File No: SF17/41212
Ref No: DOC17/433287

Request for Response to Submissions – O’Connell Street Public School (SSD 7372 Mod 2)

Mr Rajeev Maini
Acting Manager, Conservation
Heritage Division, Office of Environment & Heritage
As Delegate of the Heritage Council of NSW
1 September 2017

Figure10: North Elevation showing the Proposed location for the extension of the Plant Platform.

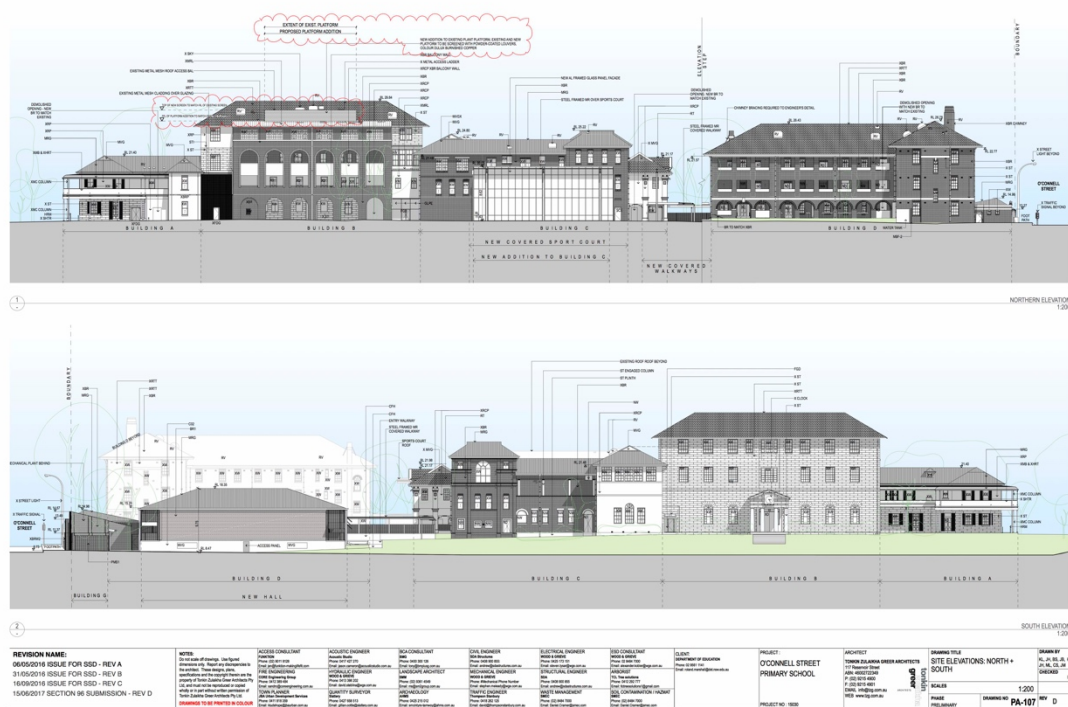
The Heritage Division, as Delegate of the Heritage Council has previously provided comment on the proposal to integrate solar panels to the roof of the new school hall and to expand the existing rooftop mechanical plant to building B. It was requested that the proponent consider further options for the relocation of the rooftop mechanical plant with the aim of removing the mechanical services from the roof in their entirety due to the increased bulk of the proposed plant and adverse heritage impacts.

The proponent has stated that other options for the relocation of the mechanical services discounted in favour of the current option due to it being considered to have the least adverse heritage impact. It is, however, noted that no details of any options considered have been submitted to adequately demonstrate this argument. For example, whether consideration was given to distributing the overall number of units required by locating the extra air conditioning units to service building C in discreet locations such as on the new roof to the courtyard of building C.
